CITY OF ALBUQUERQUE

January 24, 2018

RE: **Anderson Heights Unit 5 Park**
Engineer's Stamp Date: 2/15/2018
Hydrology File: N08D006C1

Based on the information provided in the submittal received on 2/15/2018 the above-referenced Grading and Drainage Plan cannot be approved for Grading Permit until the following comments are addressed.

GRADING AND DRAINAGE PLAN

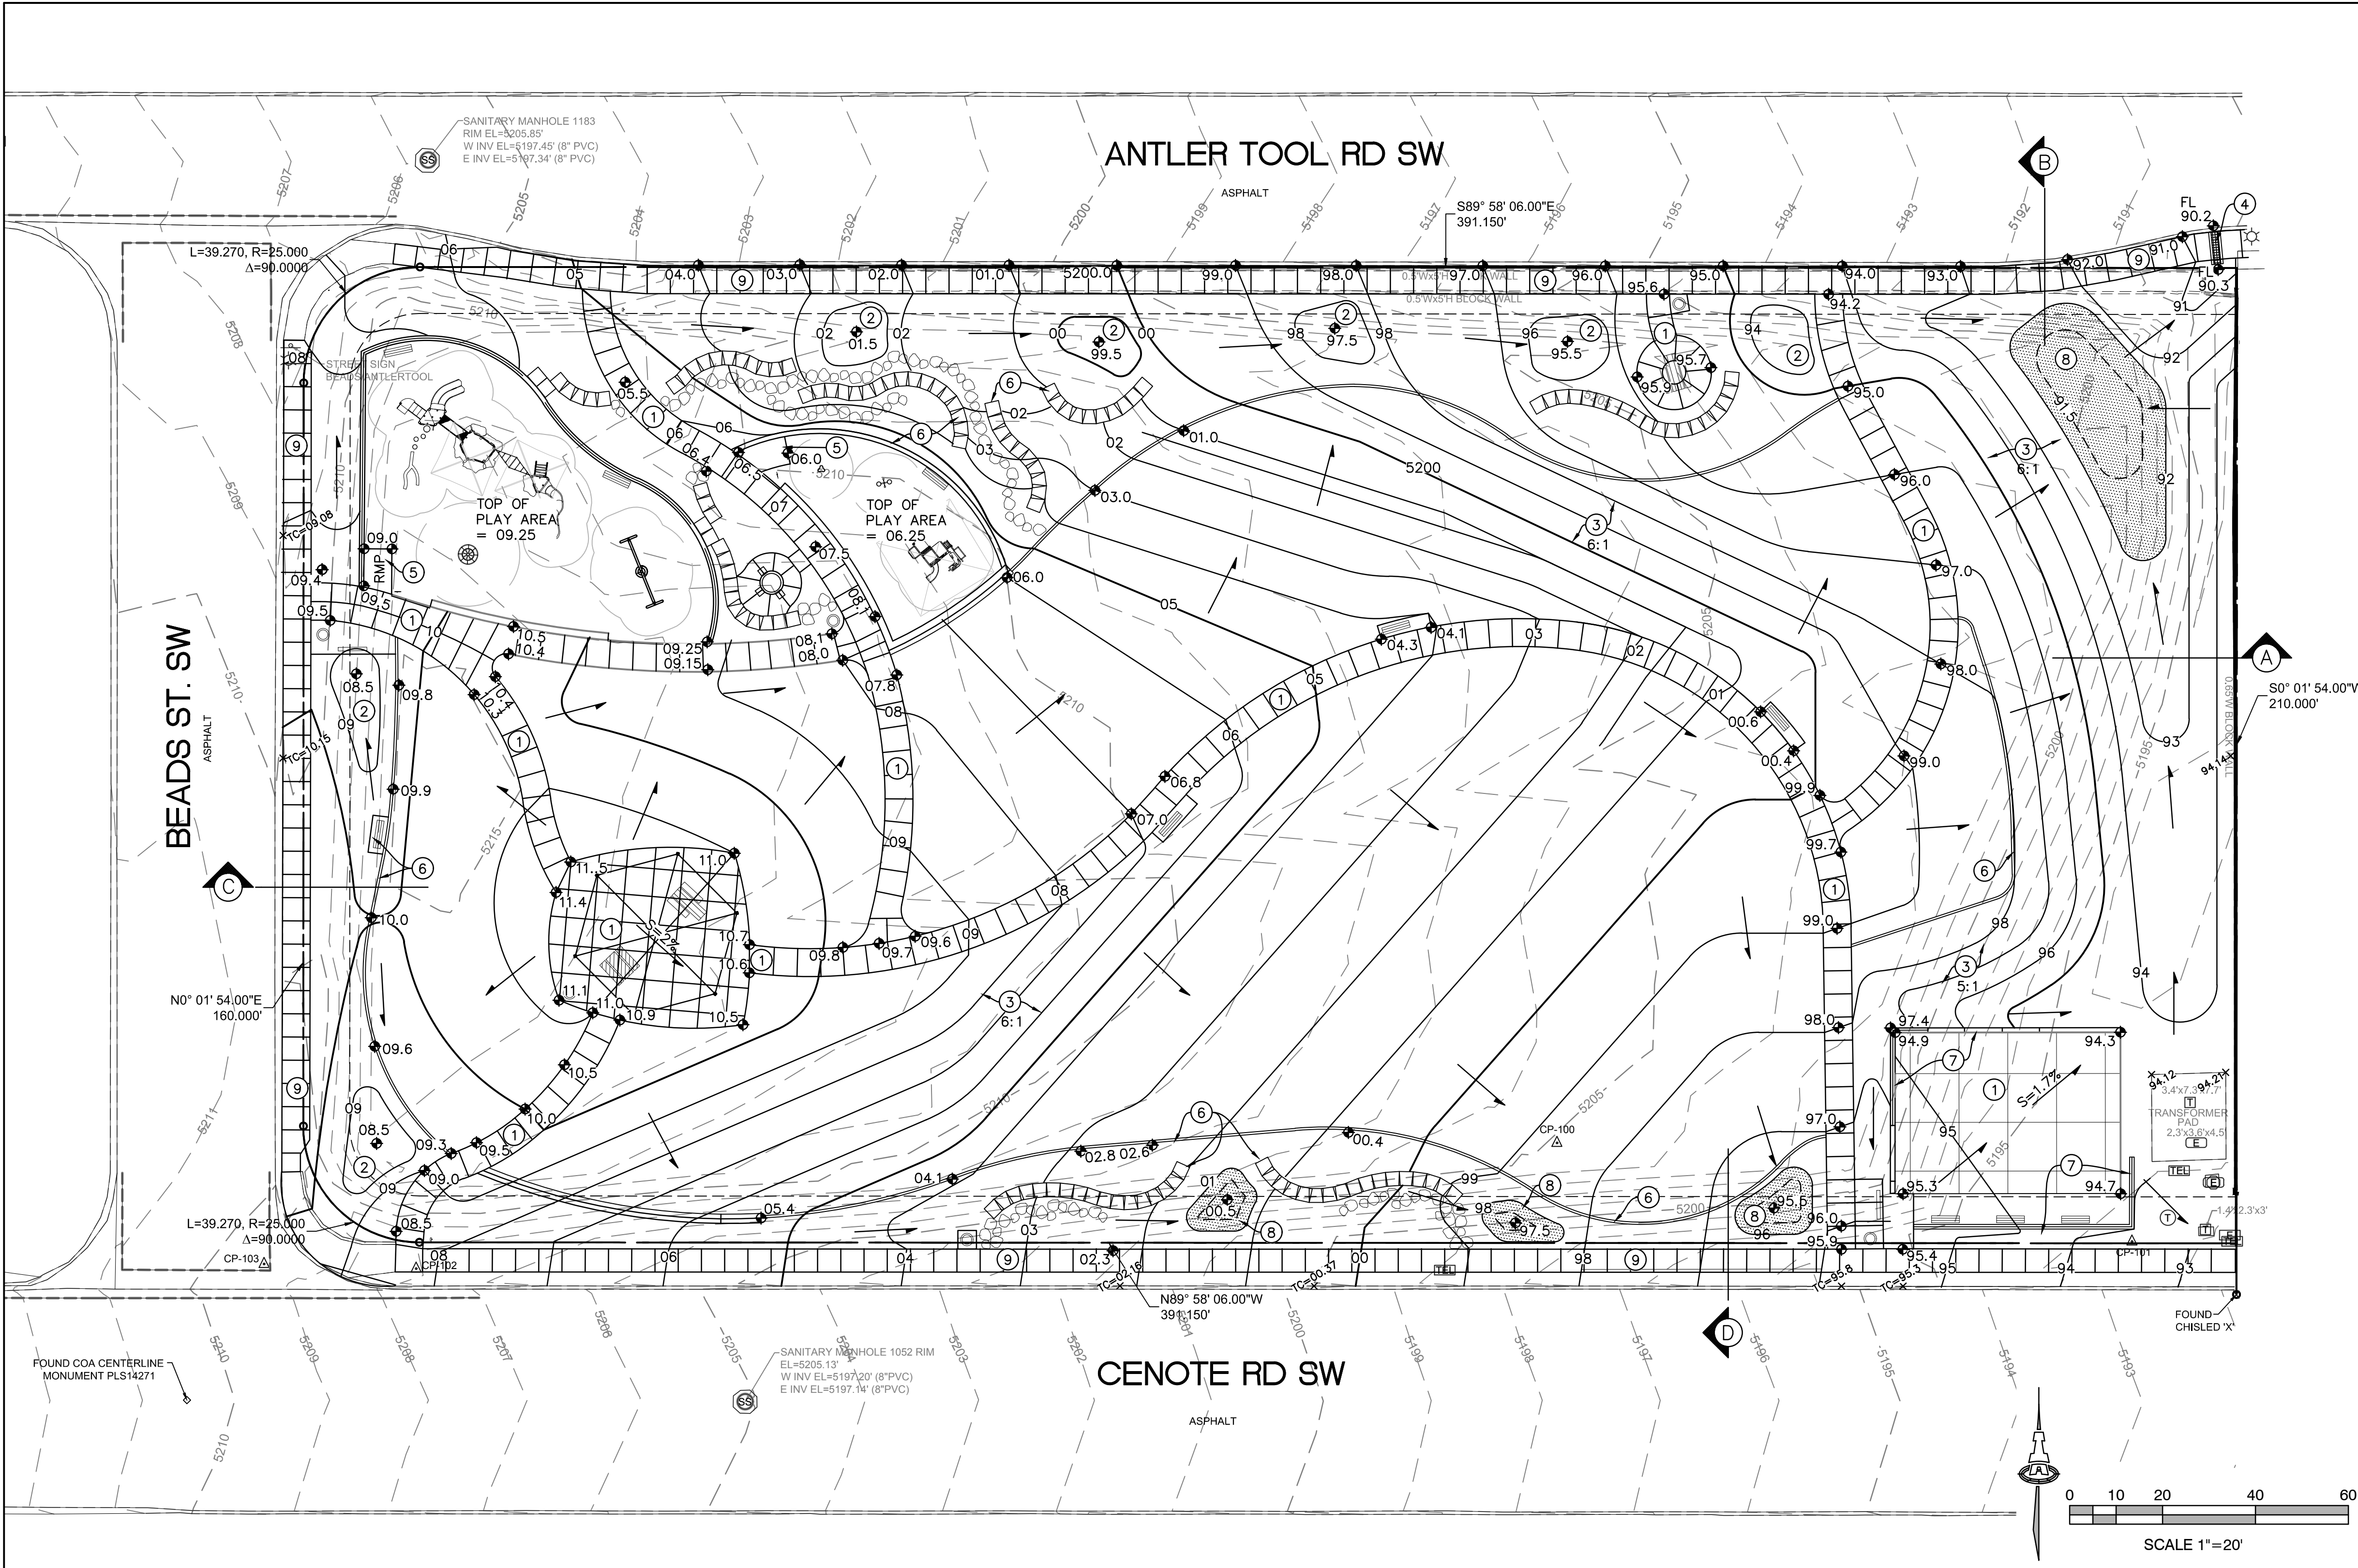
2. The Public Right of way and any other property lines and easements must be clearly indicated on the G&D Plan. State the source of the survey information in a note on the G&D Plan.

3. Typical sections must be added on the G&D Plan thru the edges of the site showing existing and proposed grade, existing and proposed improvements (Sidewalks & C&G), the property line, and maximum and minimum dimensions both vertical and horizontal. Per DPM 22.5.B, "Care should be taken to ensure that existing foundations, retaining walls, stable slopes or other structures are not endangered and that the adjacent property is not damaged or its use constrained due to grading at or near the property line" particularly on the east side.

4. Add a note on the plan stating that an Excavation Permit is required for all work in the Public Right of Way.
